# Appeal Decision

**Appeal Ref: APP/T2350/D/15/3133444**

**The Holly, Wardsley Road, Chipping, Lancashire PR3 2QT**

- The appeal is made under section 78 of the Town and Country Planning Act 1990 against a refusal to grant planning permission.
  - The appeal is made by Mr Potter against the decision of Ribble Valley Borough Council.
  - The application Ref 3/2015/0318, dated 2 April 2015, was refused by notice dated 17 August 2015.
  - The development proposed is a roof extension above garages to form live-in carer space.
-

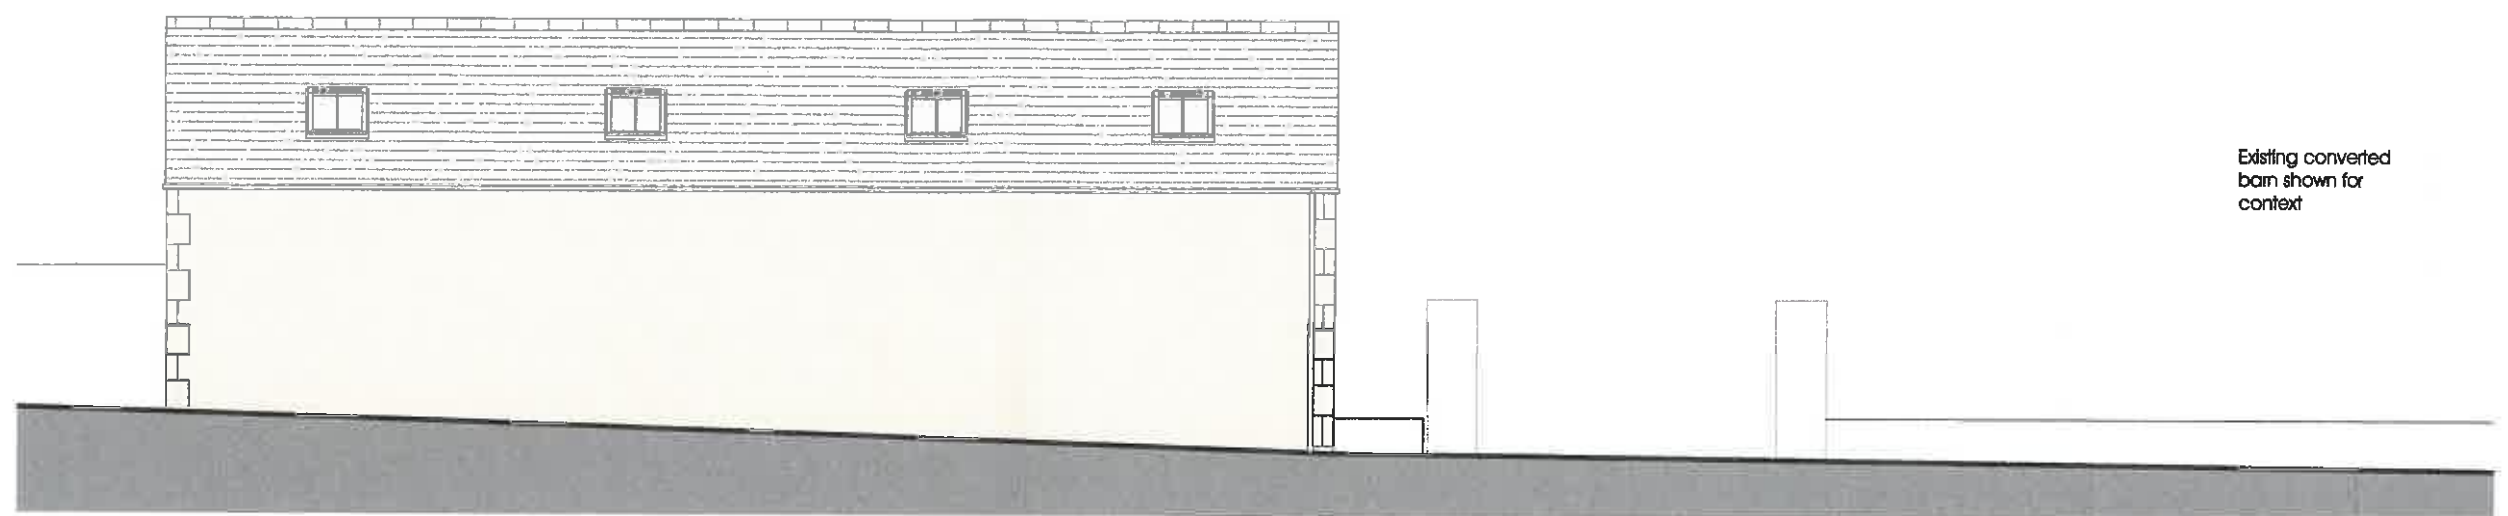
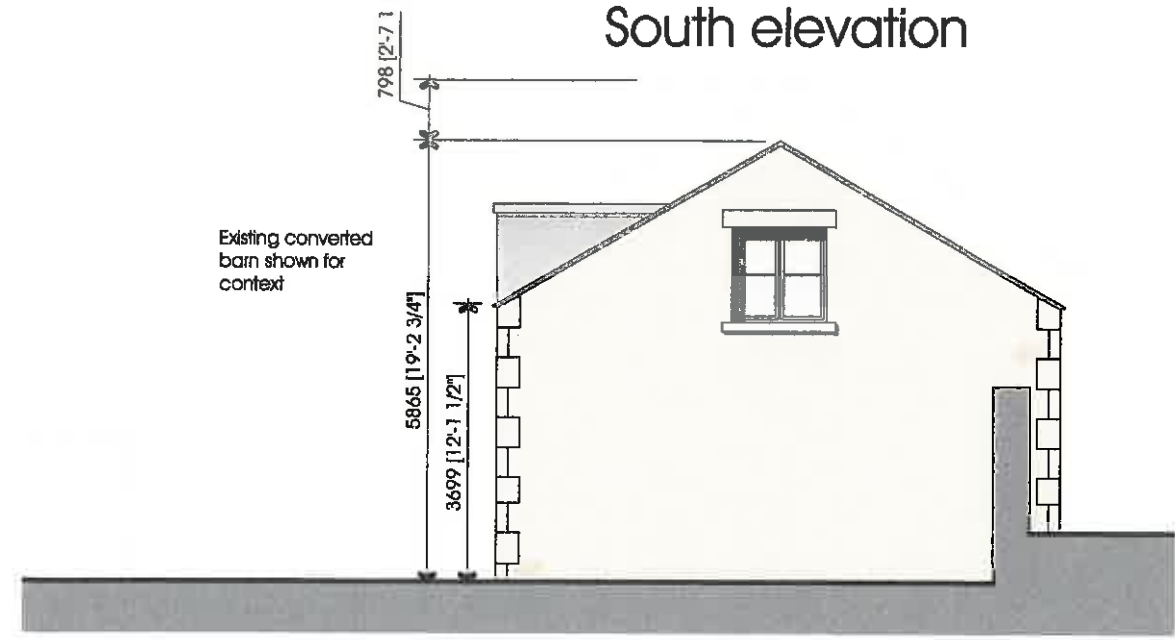
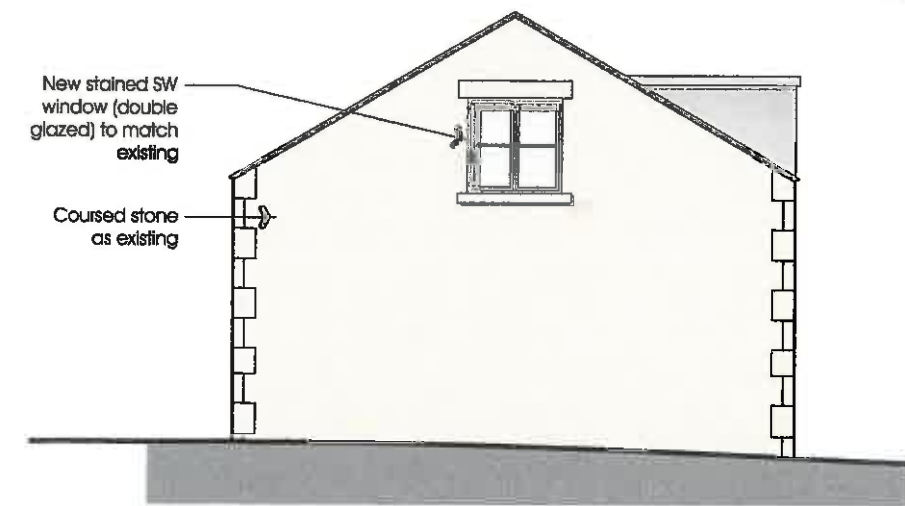
- dwellings, either by way of their scale or their function. This is the case with the current garage on the appeal site.
6. The proposal would significantly increase the scale and the mass of the garage. In addition, the development would involve the insertion of windows on both roof planes and the gable elevations. As a result, the garage building would no longer appear as a subservient building to the main dwelling in either its scale or its appearance, but would compete with it and detract from its setting. It would therefore appear out of keeping and would be detrimental to the character and appearance of the area.

7. In particular, as dormer windows are not a feature on buildings in the locality, the three proposed on the northern roof plane would be incongruous and alien features that would not respect the distinctive character of the area. I appreciate that these would be on the roof plane that faces into the site but as noted above this can be seen in places from the public realm, and the proposed increase in height would increase this visibility. In such views they would heighten the prominence of the outbuilding, and appear as a discordant element in the landscape.
